# **KIRKLEES METROPOLITAN COUNCIL INVESTMENT & REGENERATION SERVICE**

| Reference No:         | <b>2025/62/92198/E</b>                                  |
| Site Address:         | 107, Balme Road, Cleckheaton, BD19 4EW                  |
| Description:          | Erection of two storey and single storey side extension |

Drawing Title  
**PROPOSED**

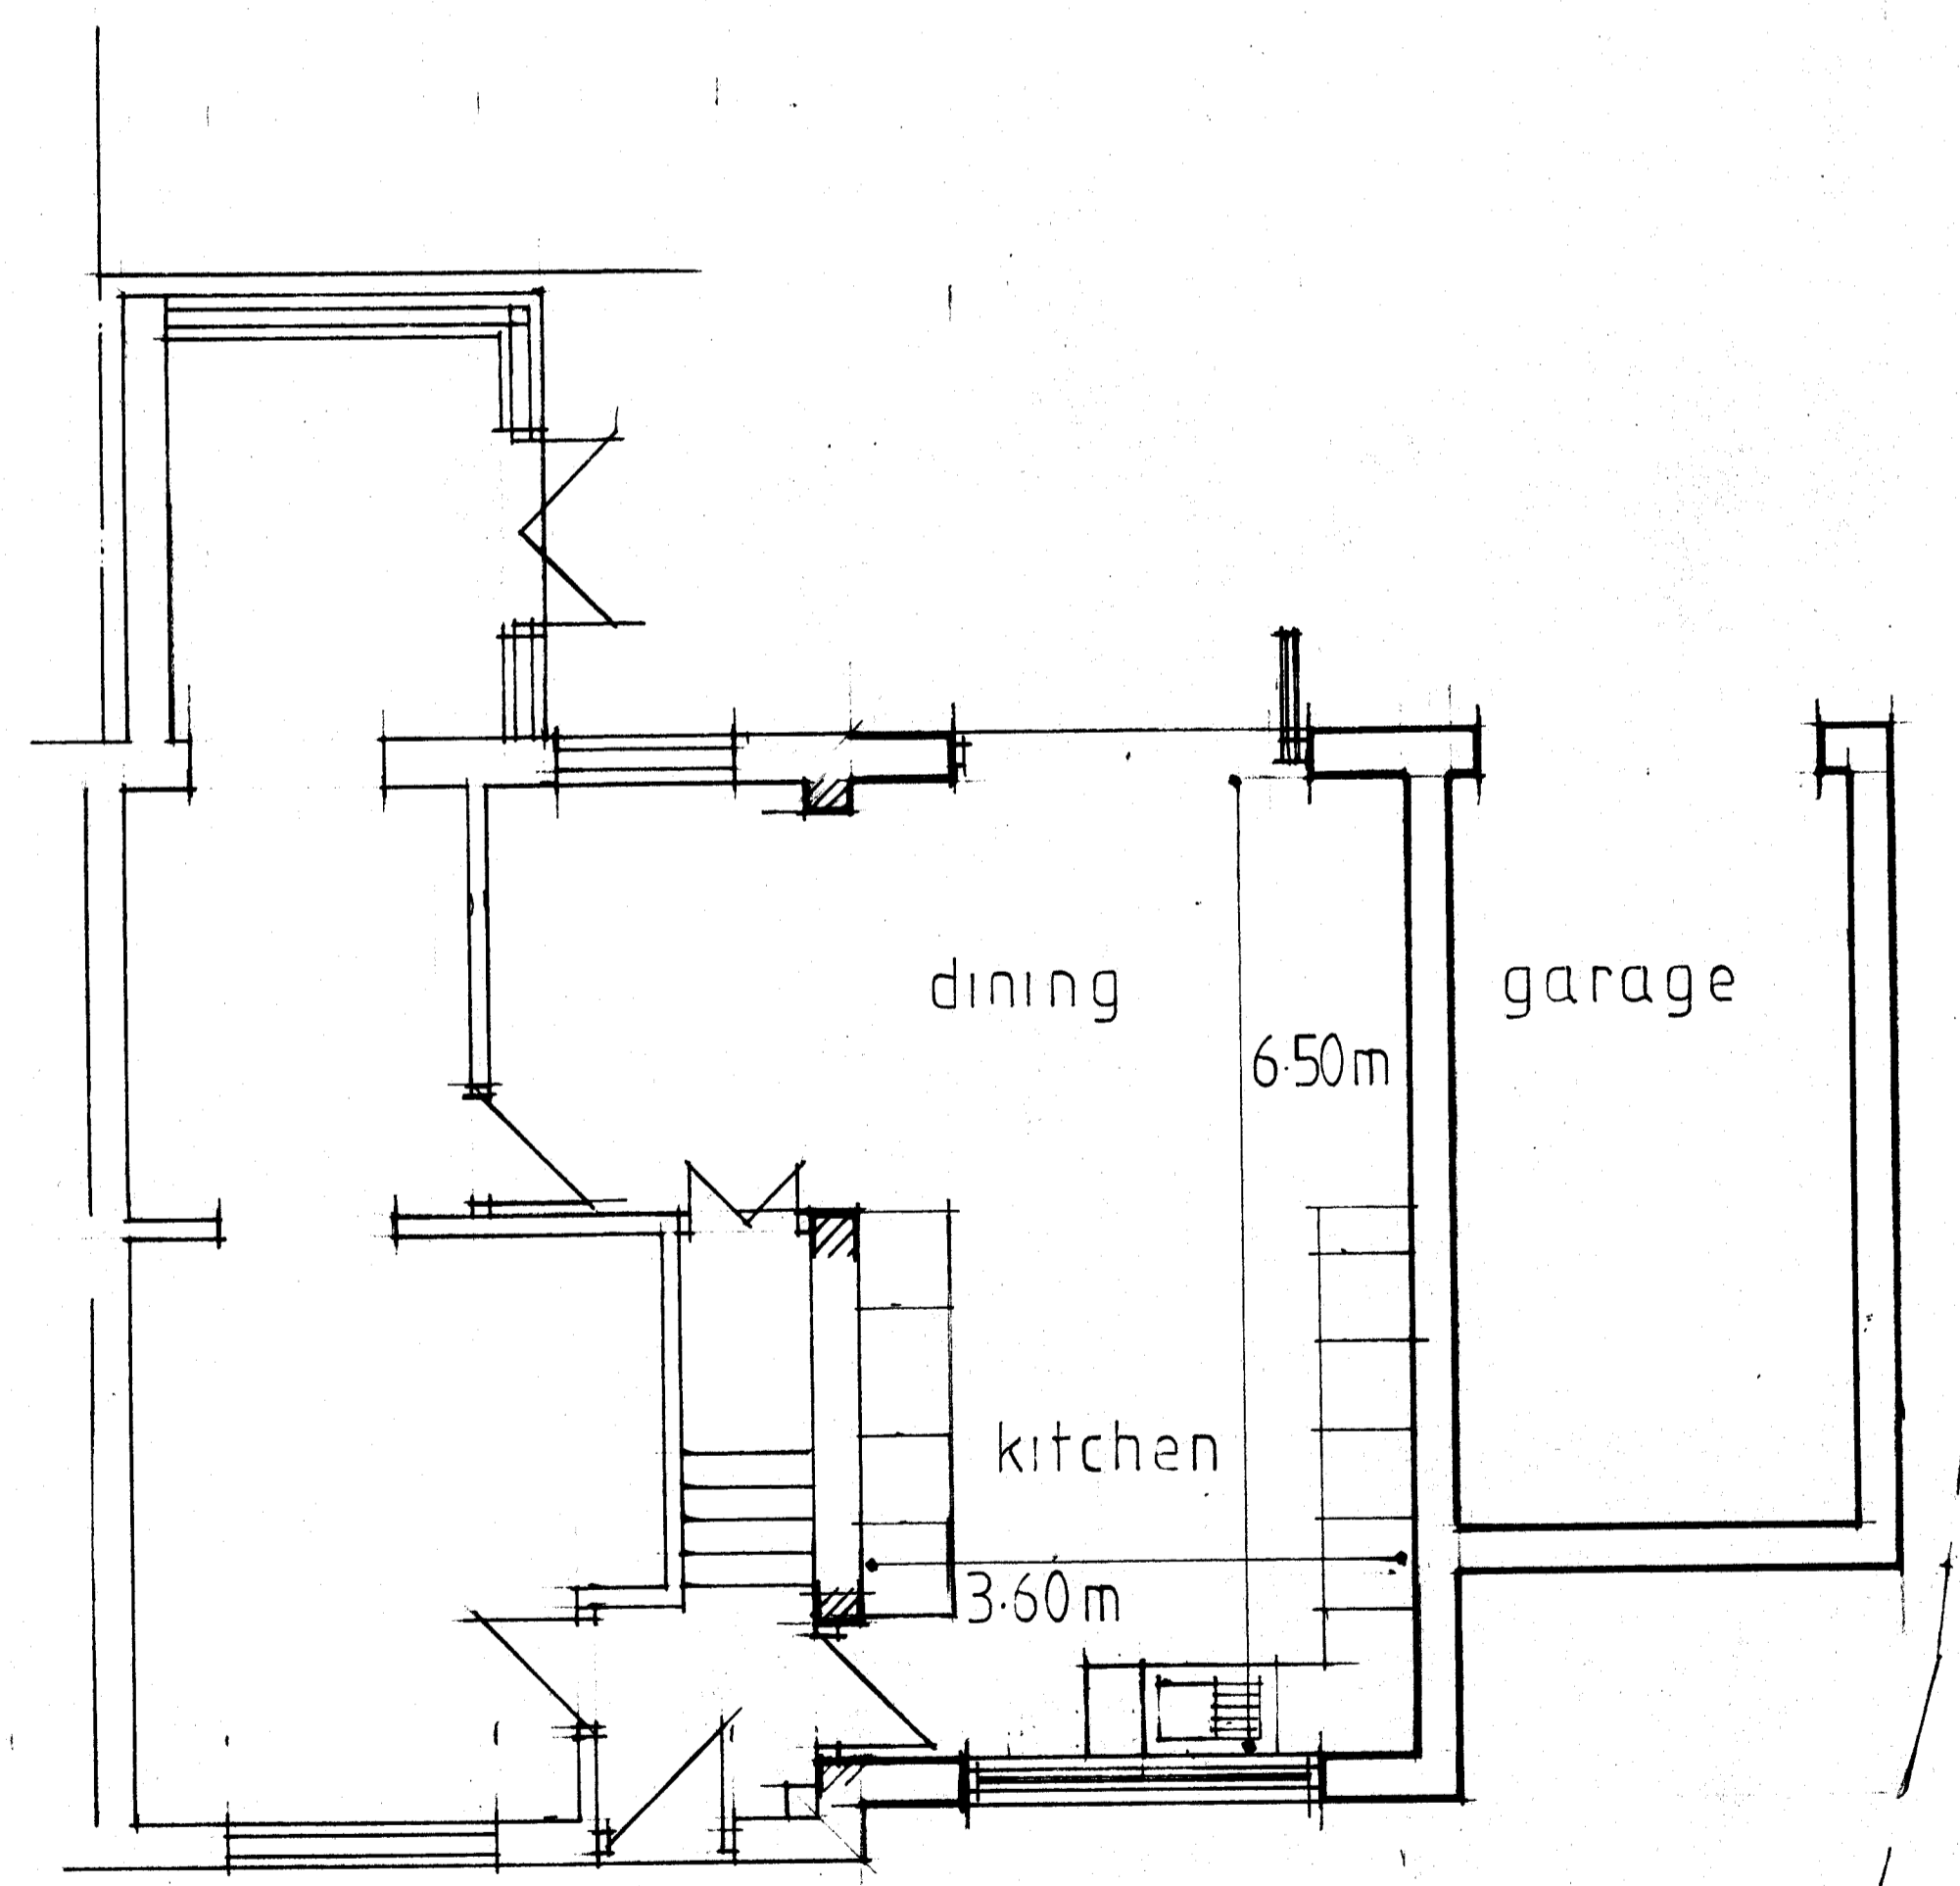
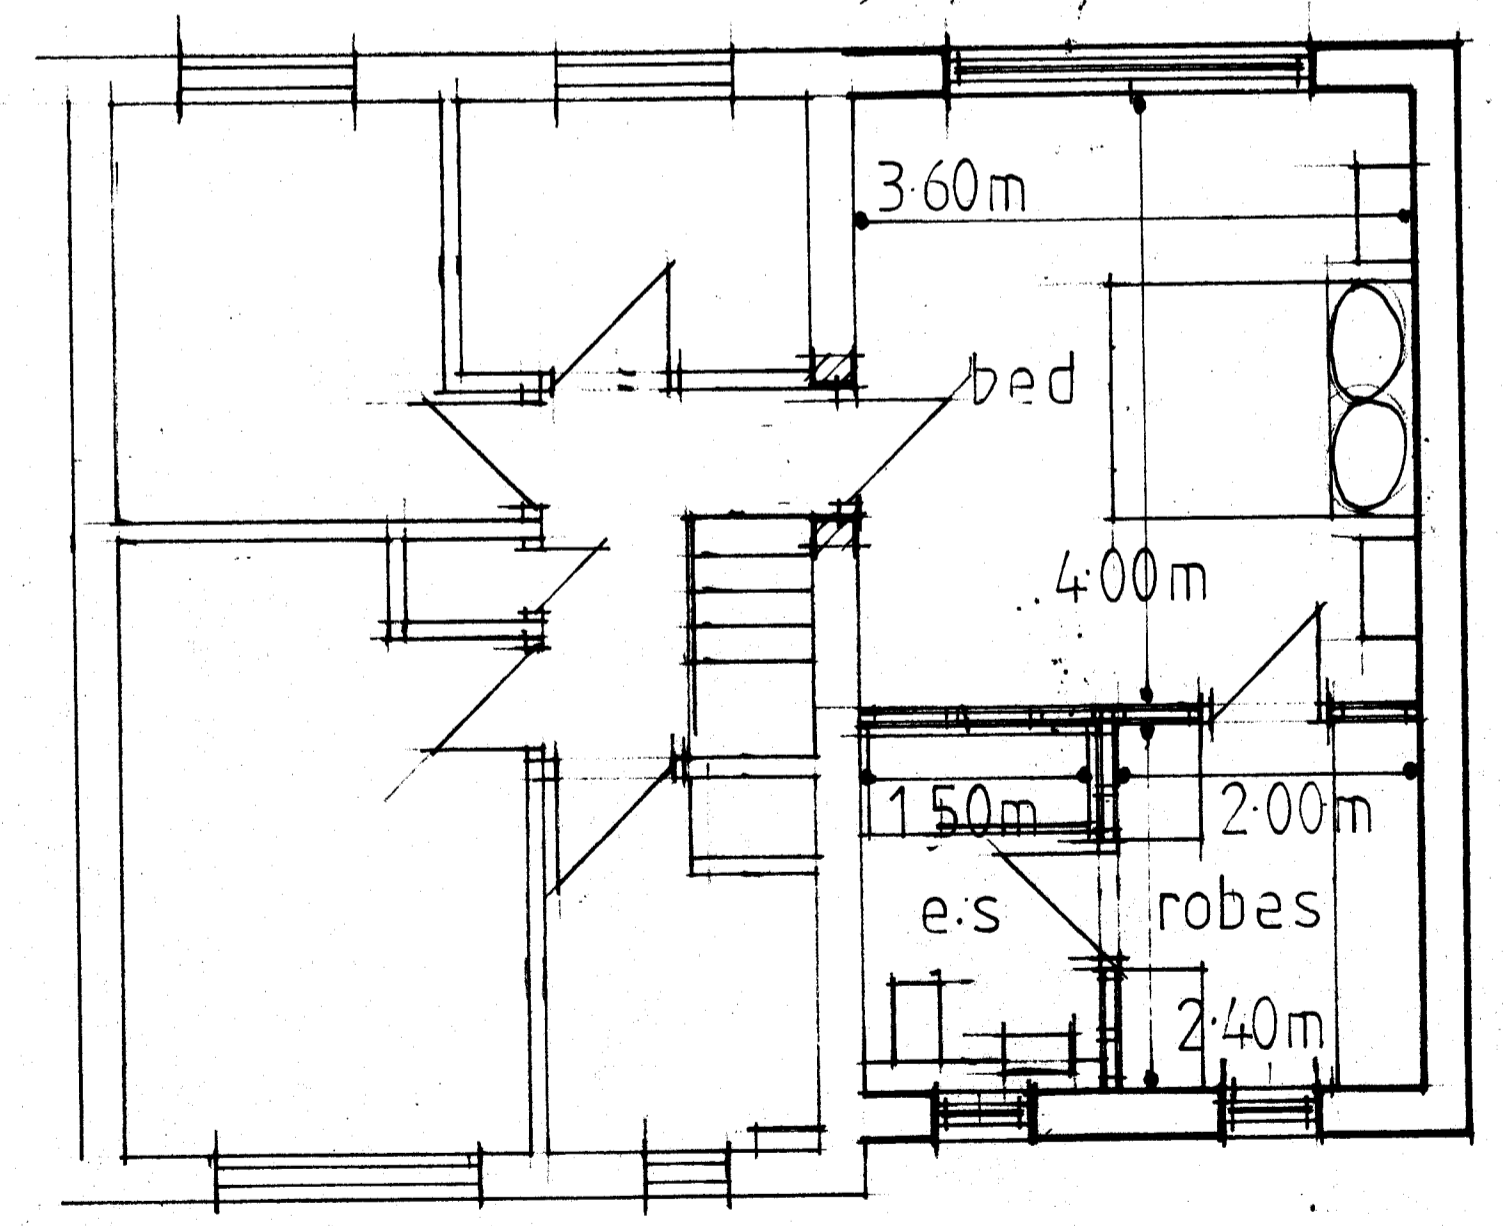
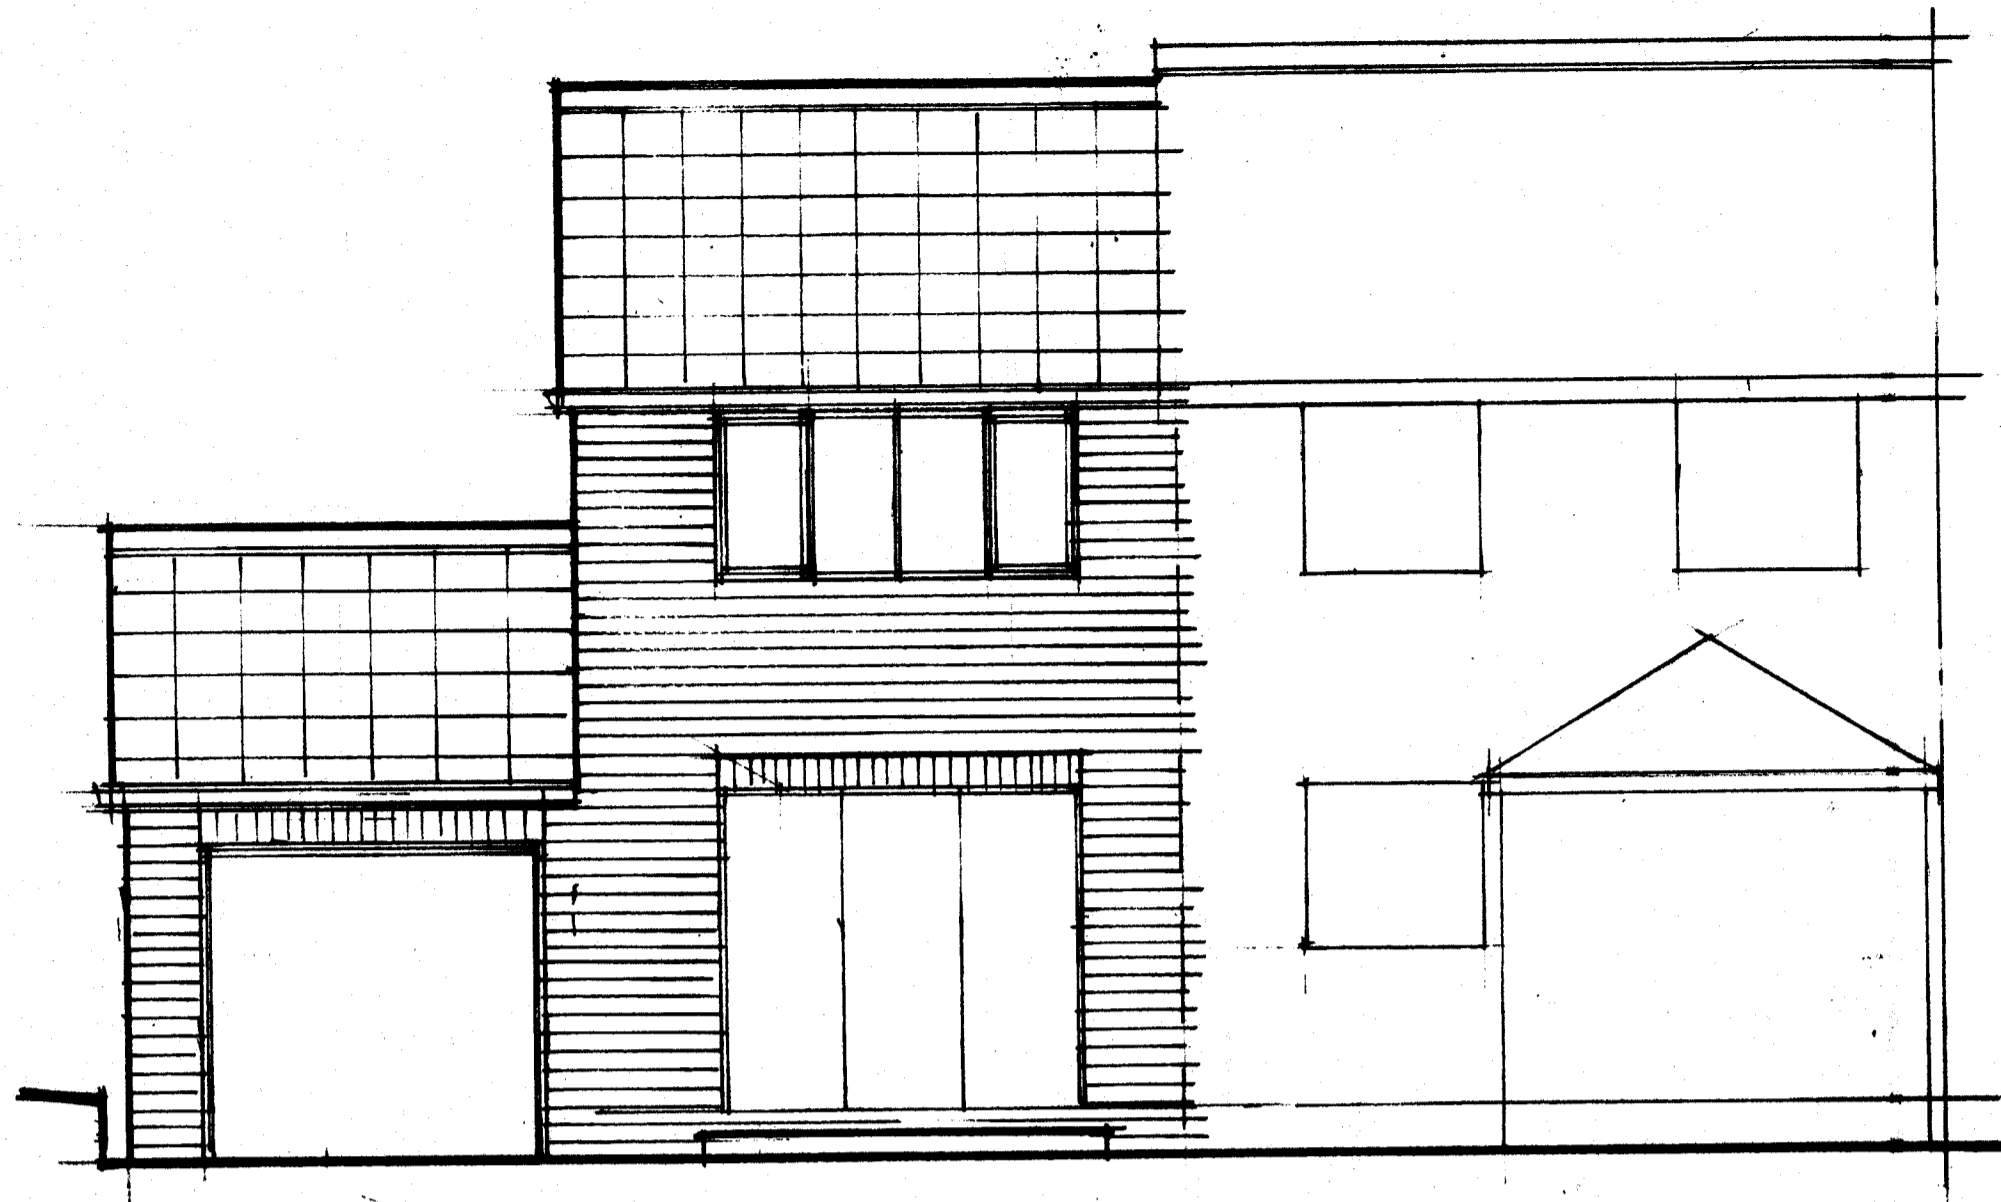
The proposals raise concerns in terms of the massing of development in the prominent position on the corner of Balme Road and Kestrel View. Amended plans have been sought and received which reduce the width, retain the garage in it existing position with roof alterations and part of the first floor over which address the concerns. As the alteration reduces the level of development, the amended plans have not been advertised.
